CITY OF ALBUQUERQUE

December 12, 2017

RE: **9401 Black Farms Lane**
Grading Plan
Engineer's Stamp Date 12/5/17
Drainage File: C13D027C

Based on the information provided in your submittal received 12/5/17, the Grading Plan cannot be approved for Building Permit until the following are addressed:

<div>ENGINEER'S SEAL</div> <div></div> <div>12/27/17</div> <div>DAVID SOULE P.E. #14522</div>	9401 BLACK FARM LN, N.W.	DRAWN BY WCVJ
	GRADING AND DRAINAGE PLAN	DATE 12-27-17
	 1606 CENTRAL AVENUE SE SUITE 201 ALBUQUERQUE, NM 87106 (505) 872-0999	21811-LAYOUT-10-16-17 SHEET # — JOB # 21808

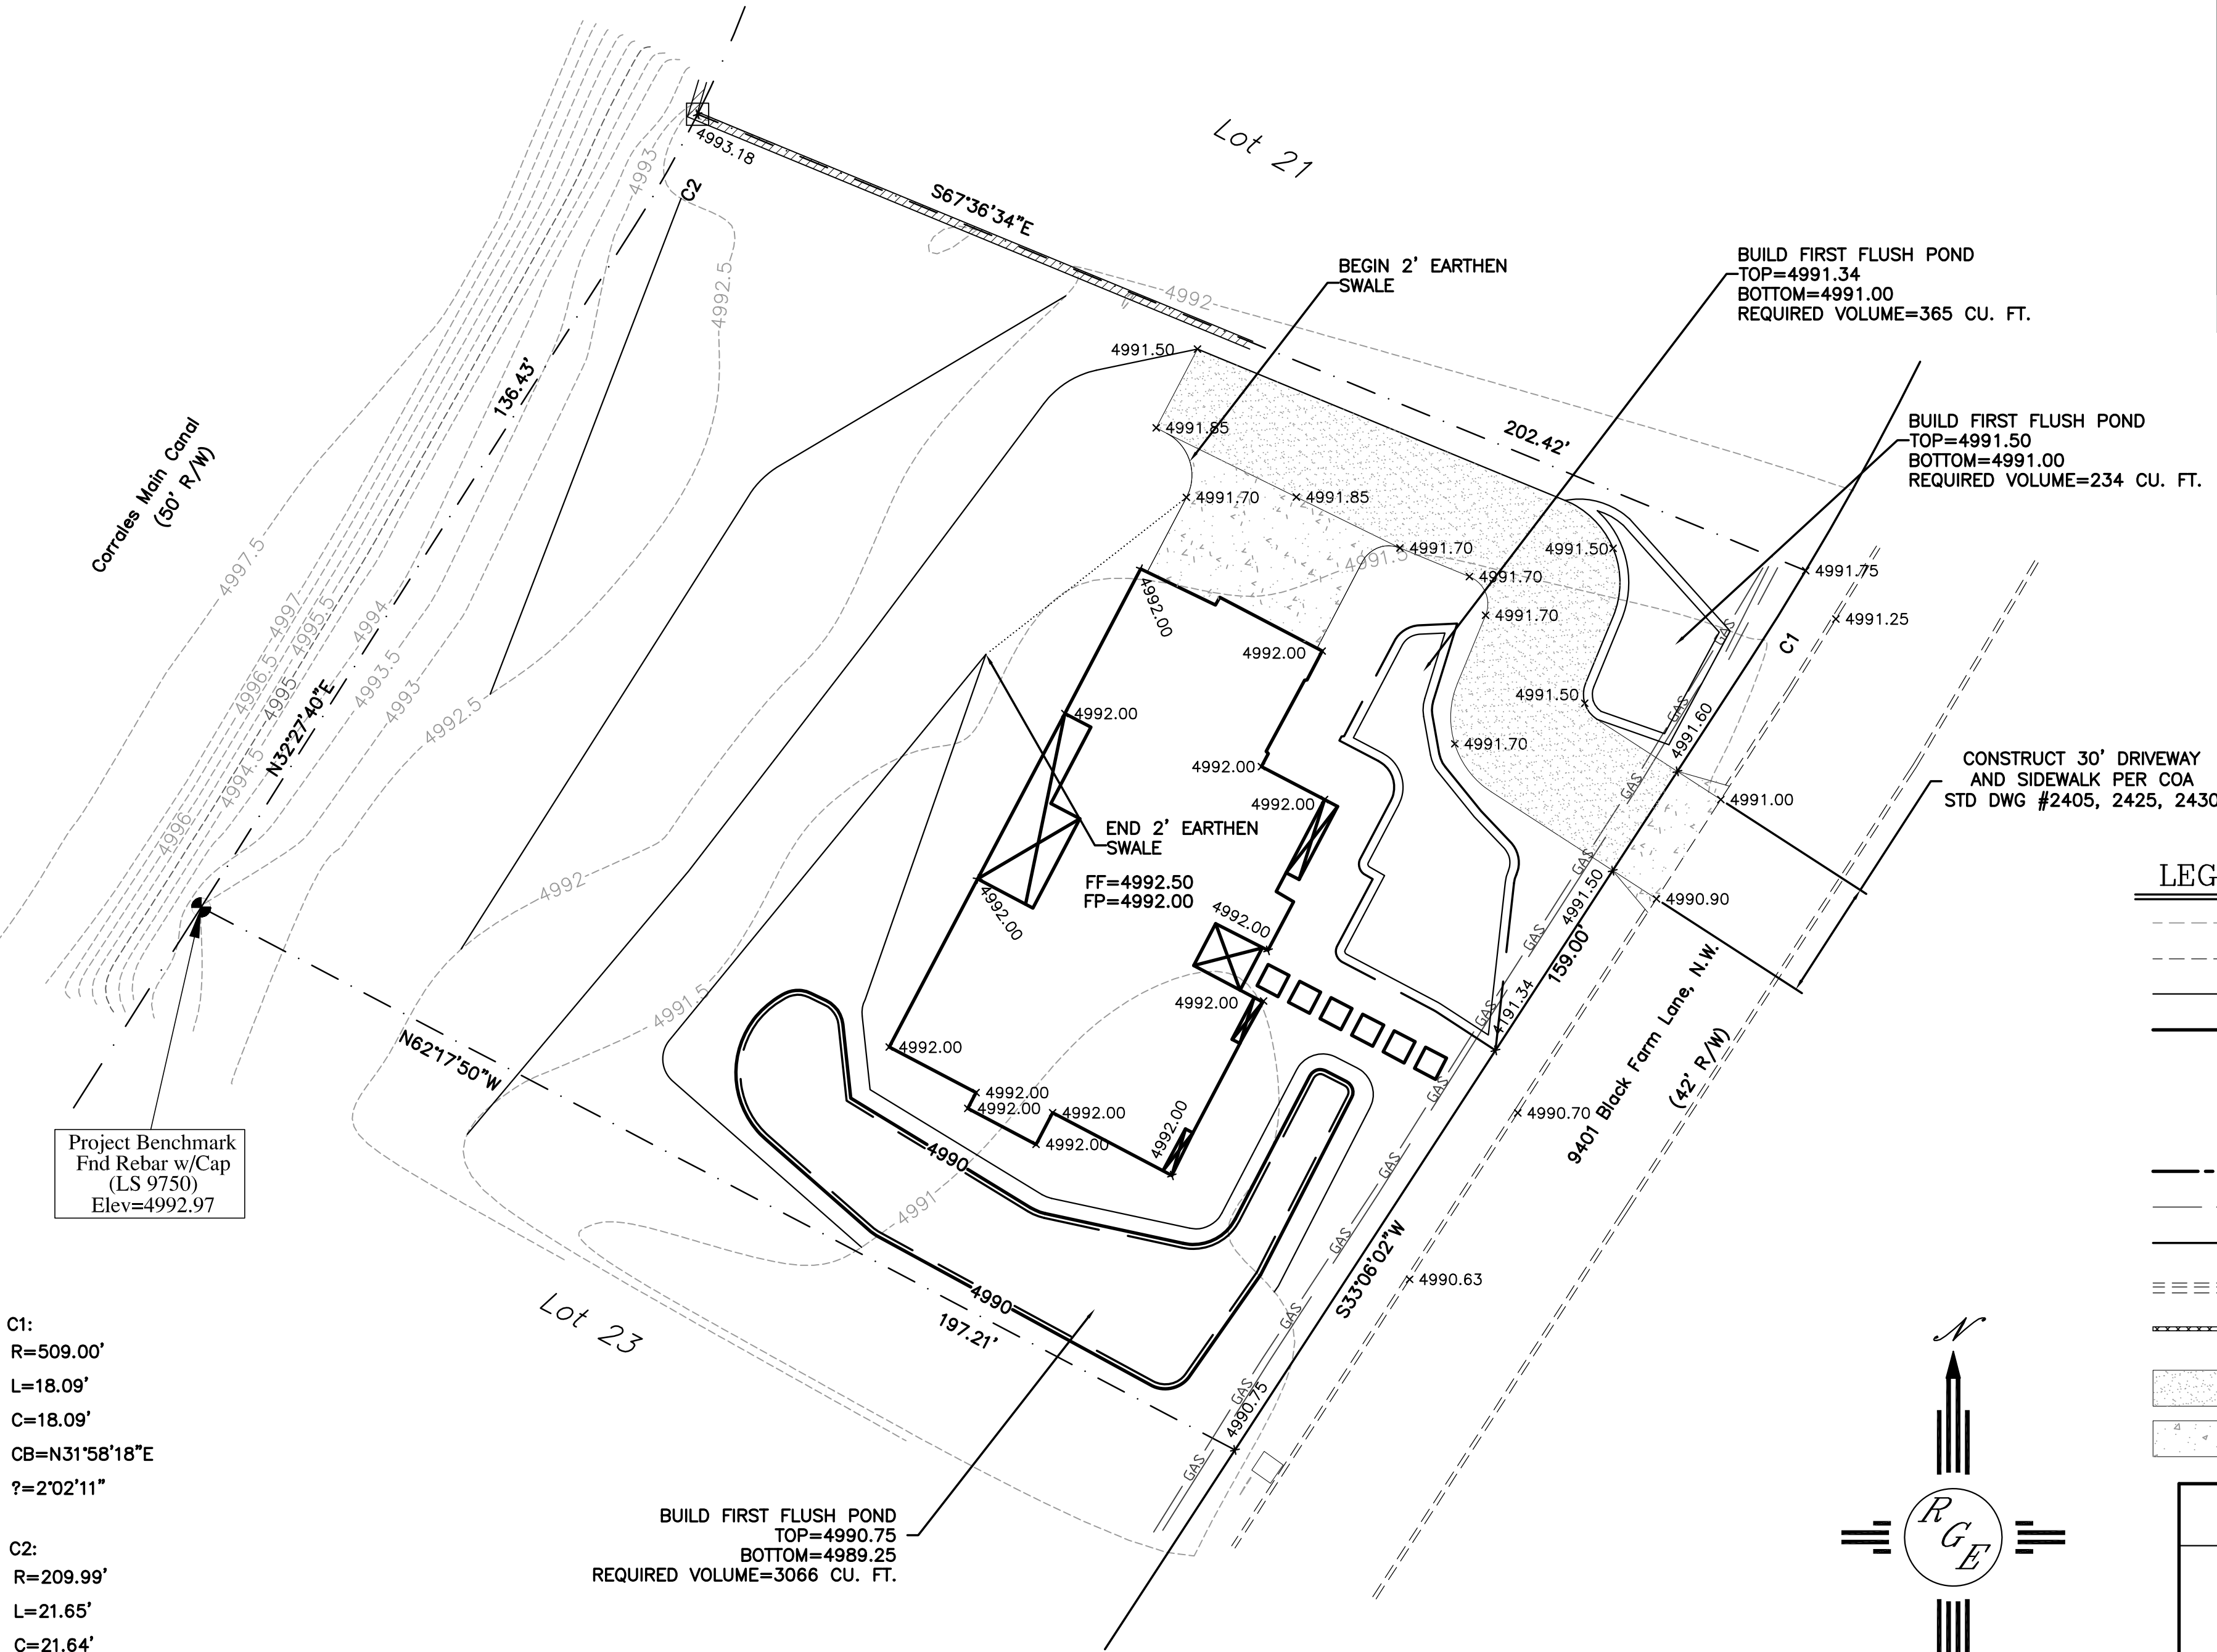
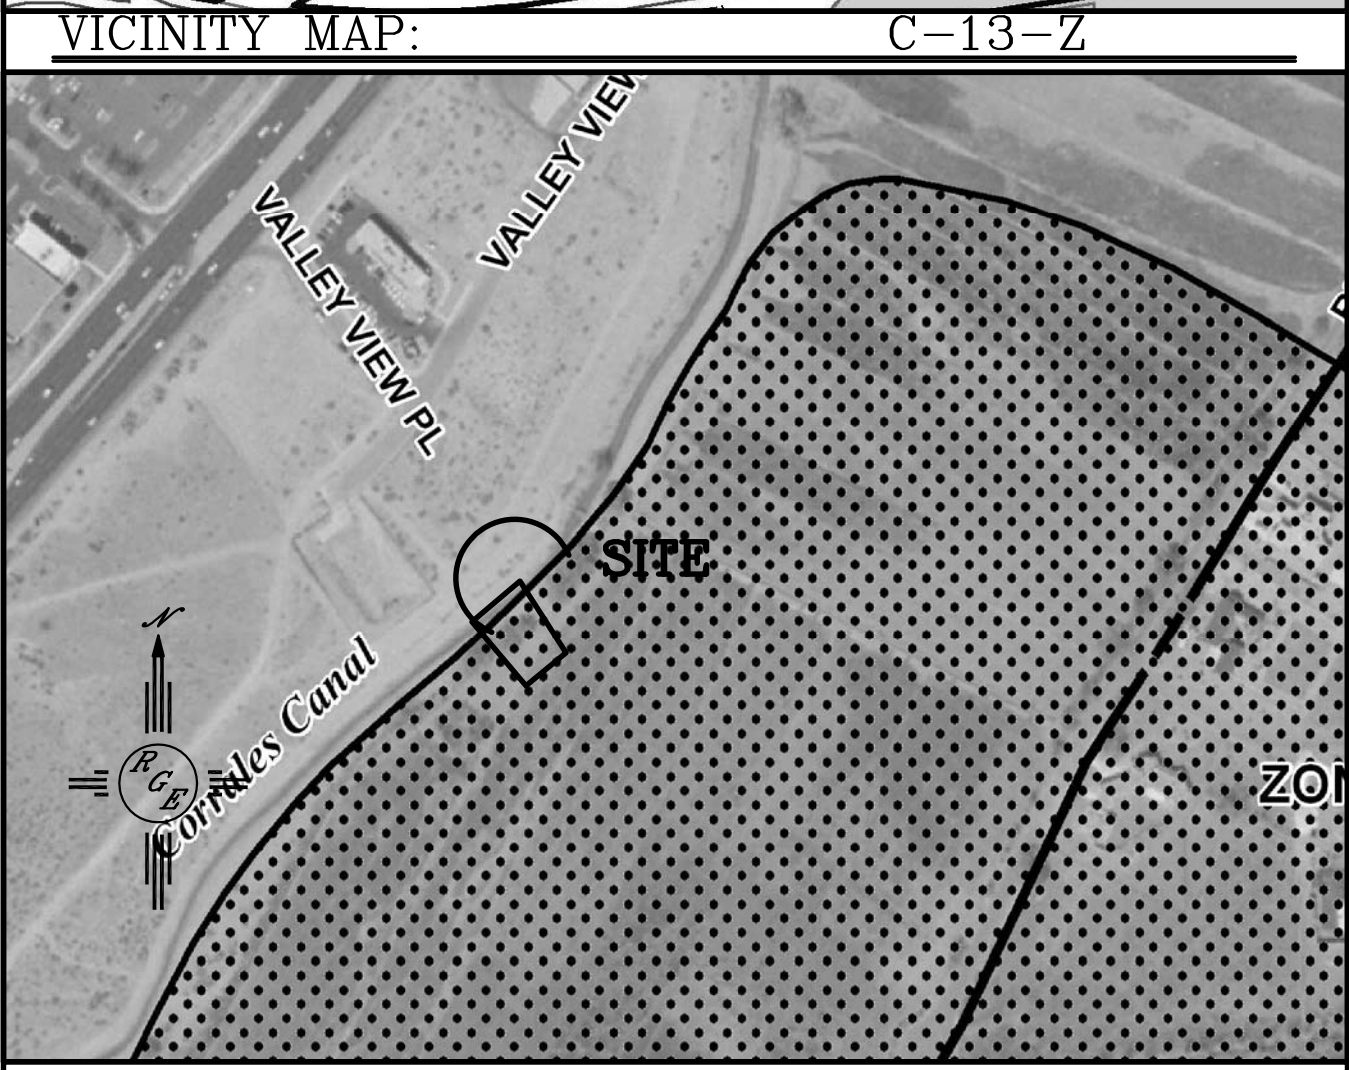
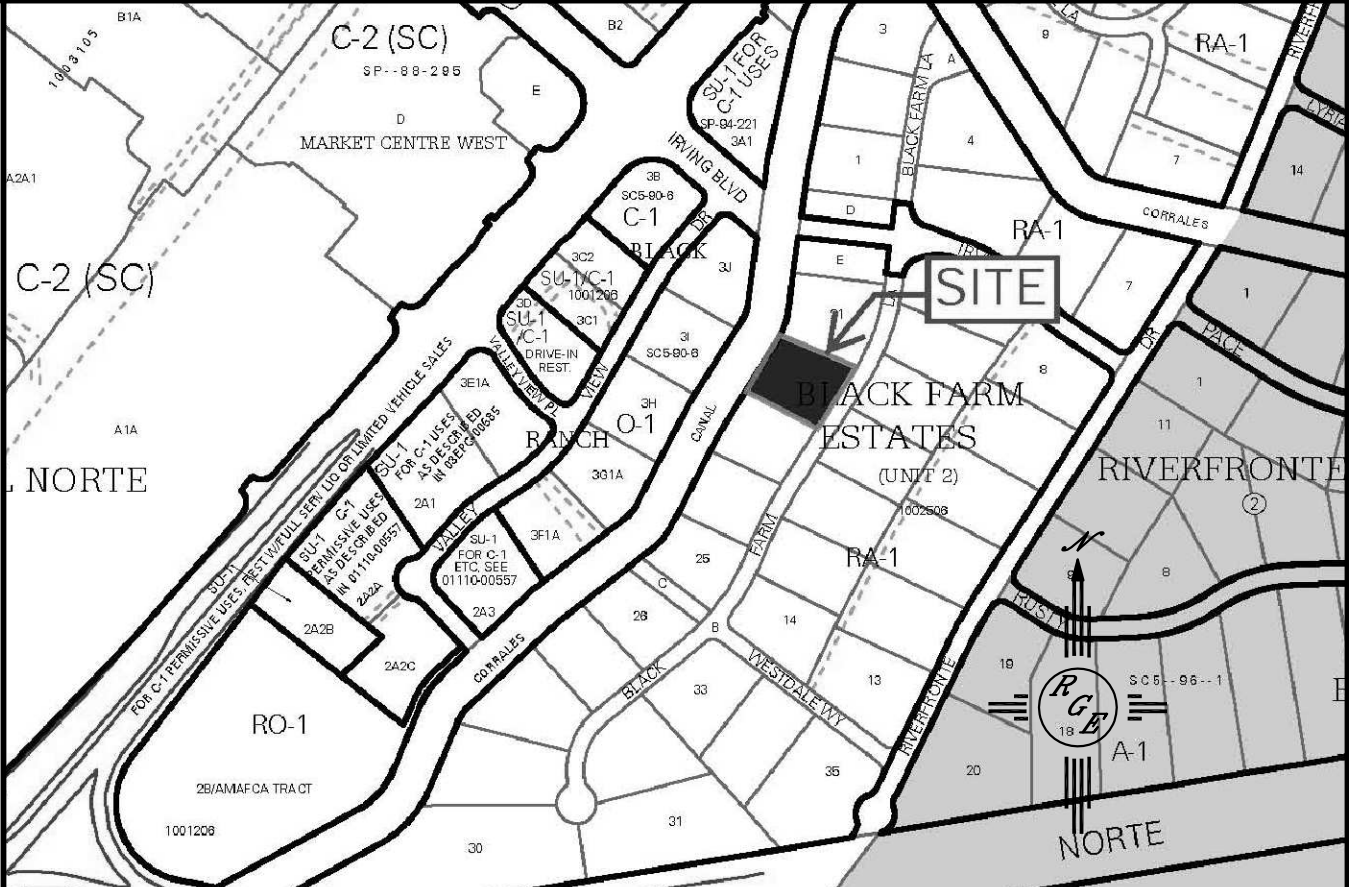
1. The approved Master Plan for Black Farms subdivision (C13D027) requires onsite retention of the developed 100-yr, 10-day volume and adherence to Valley grading criteria.
2. Ponds called for in the Master Plan were not built as part of the subdivision construction and will need to be built with each building permit.
3. It is recommended that the finished floor be elevated at least 1' above surrounding grades.
